Acceptance of Applications Checklist

Immingham Green Energy Terminal Section 55 Acceptance of Applications Checklist

SAFETY, HEALTH AND ENVIRONMENTAL INFORMATION BOX

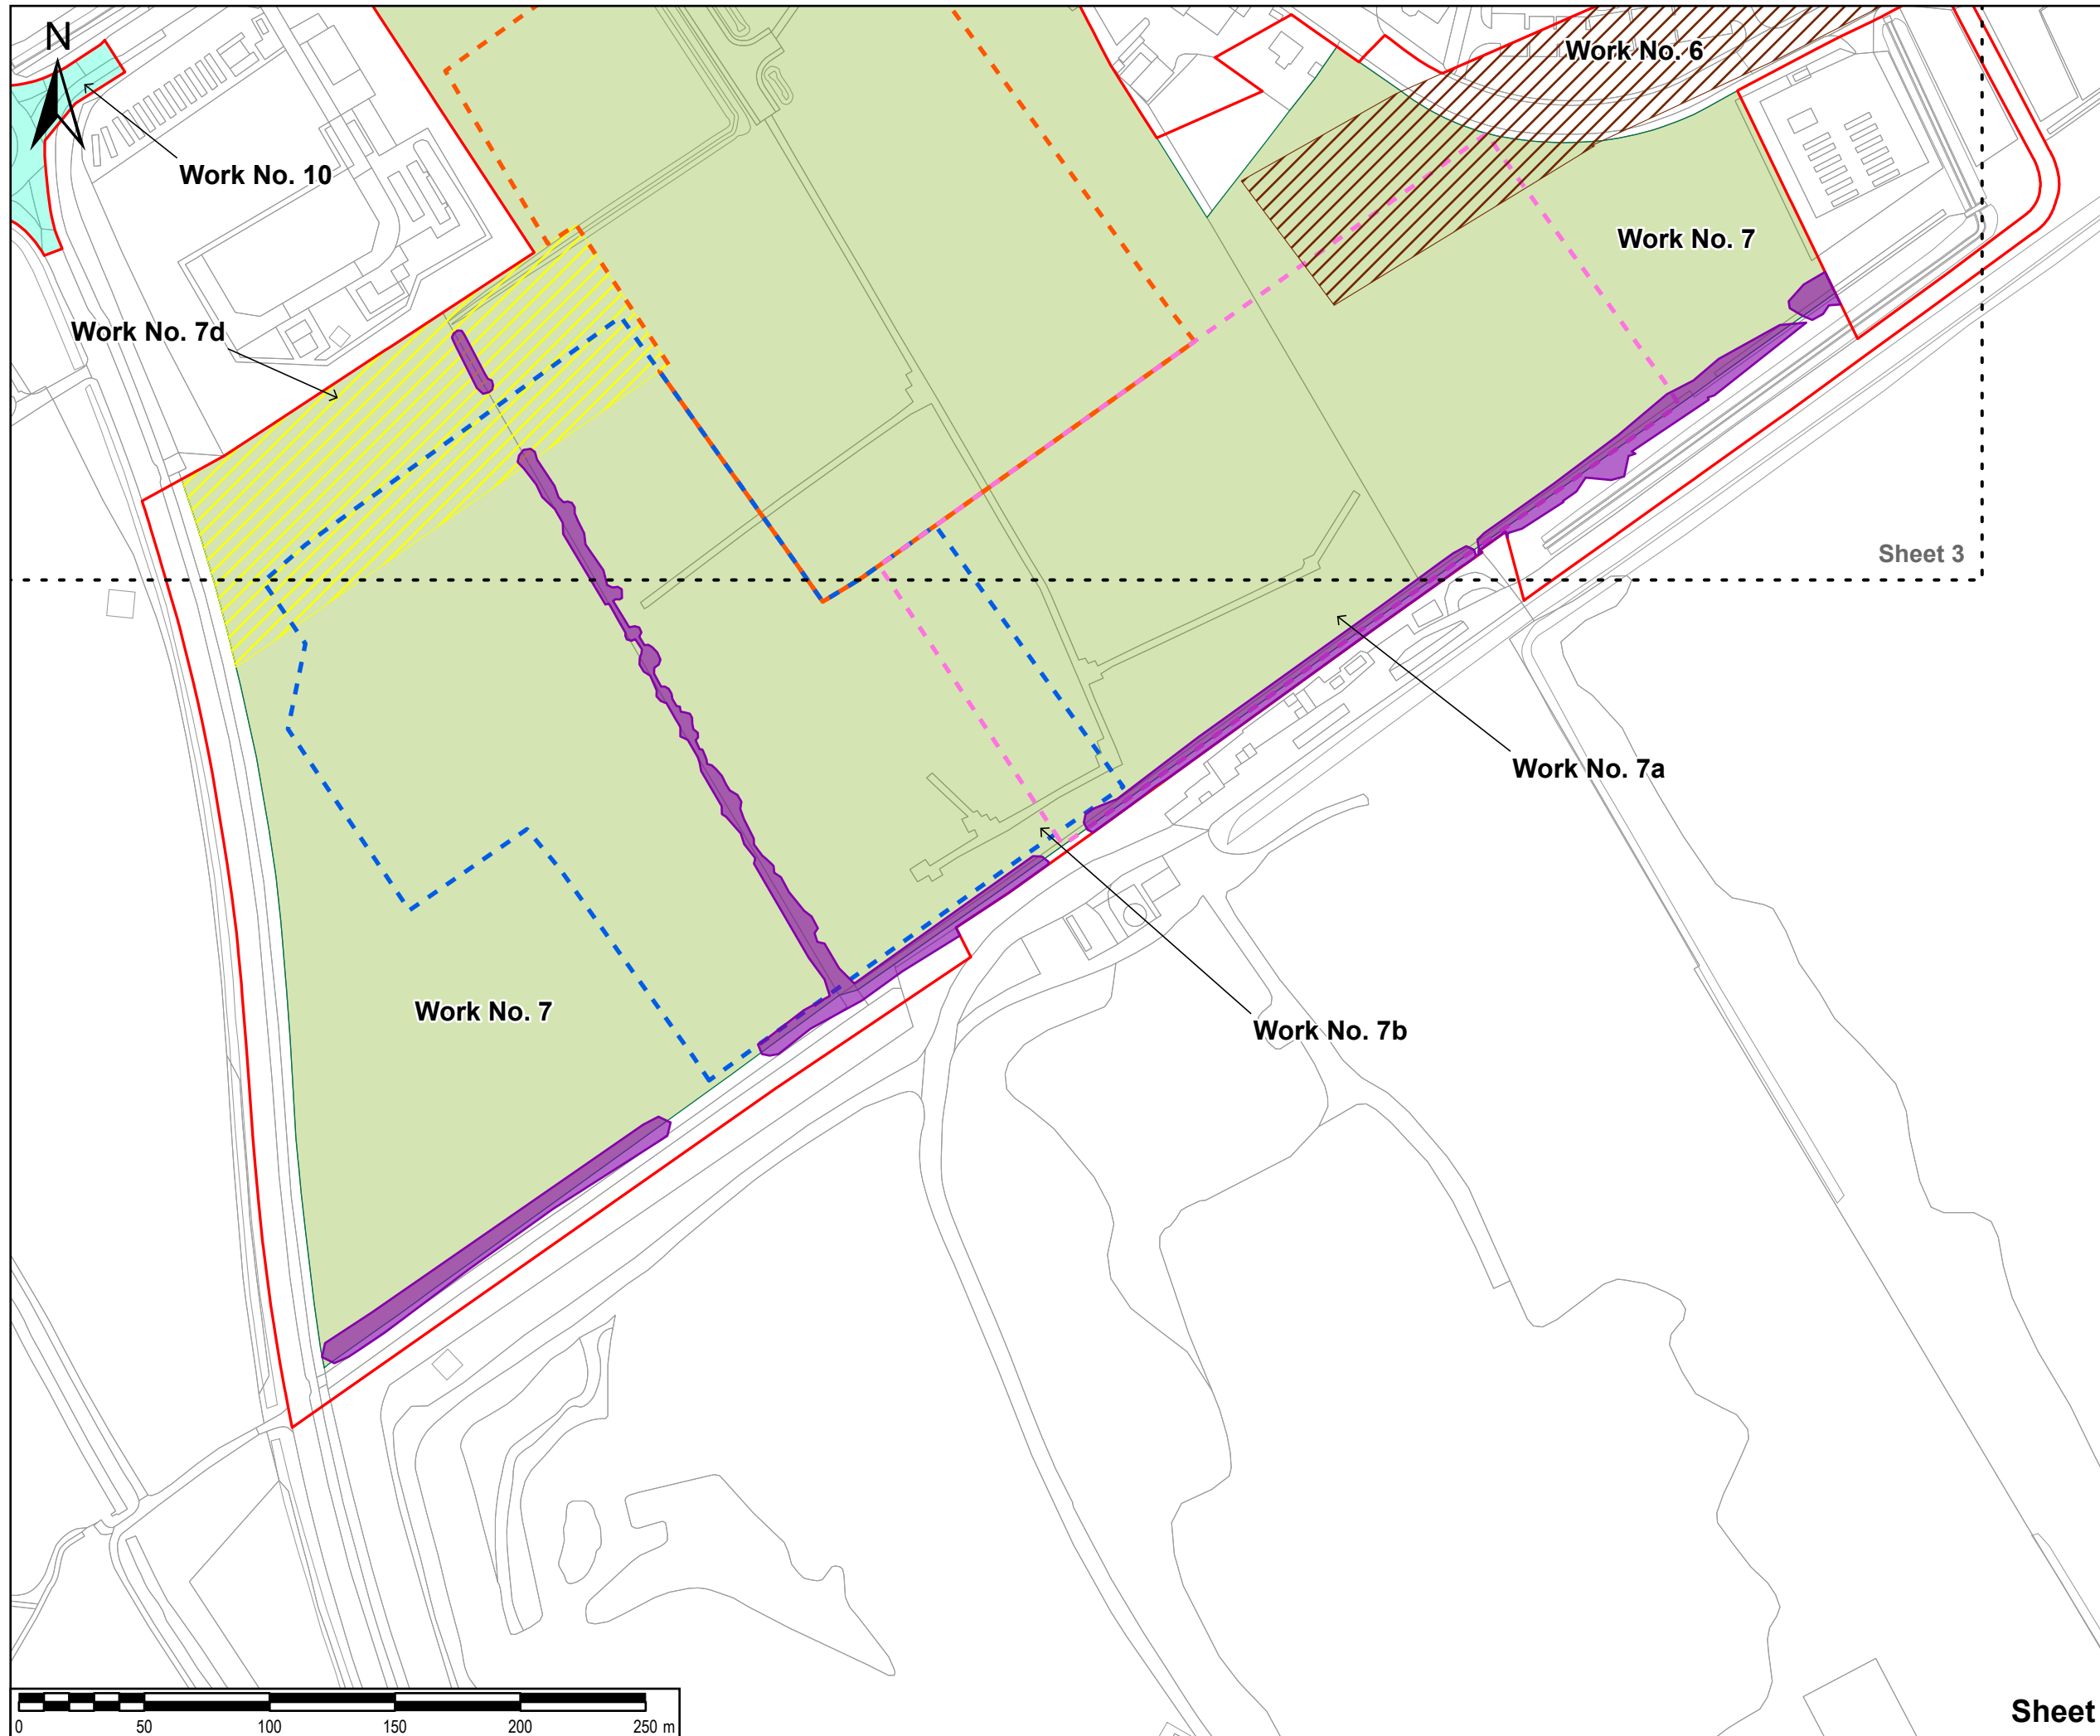
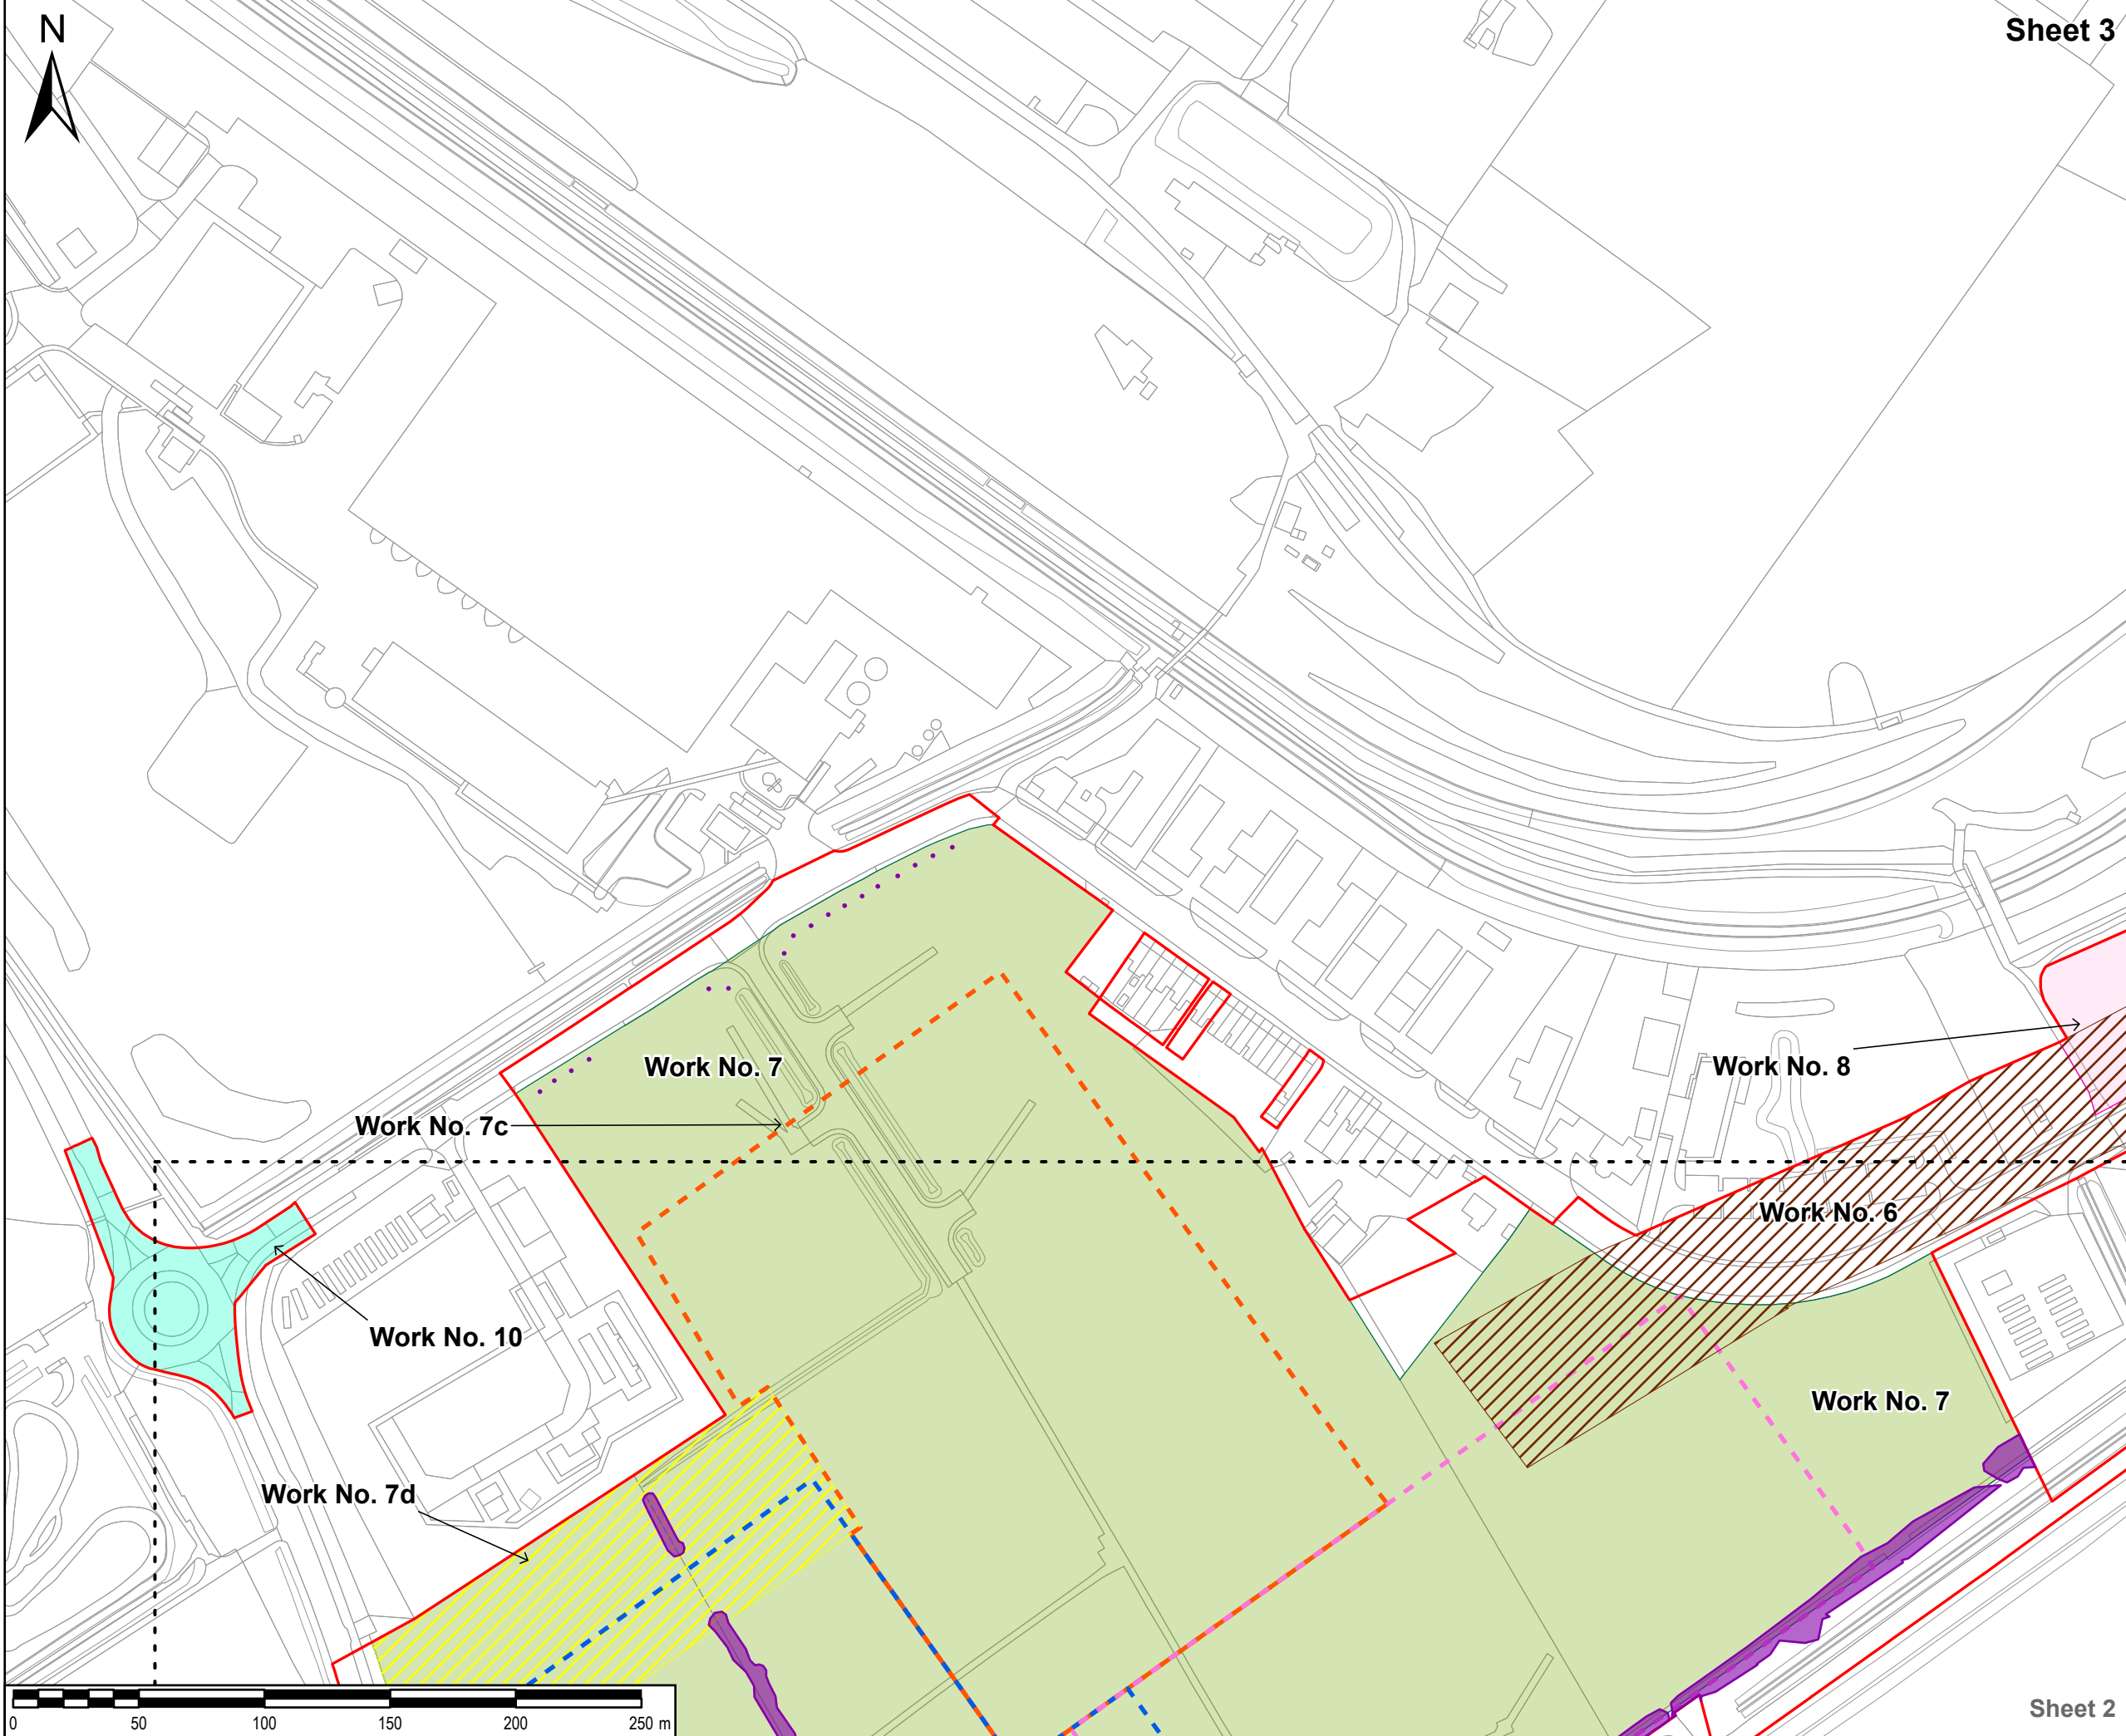
The Plan of Potentially Affected Hedgerows and Trees Subject to Preservation Orders Key Plan is attached to the end of the Traffic Regulation Measures Plan. It should be removed.
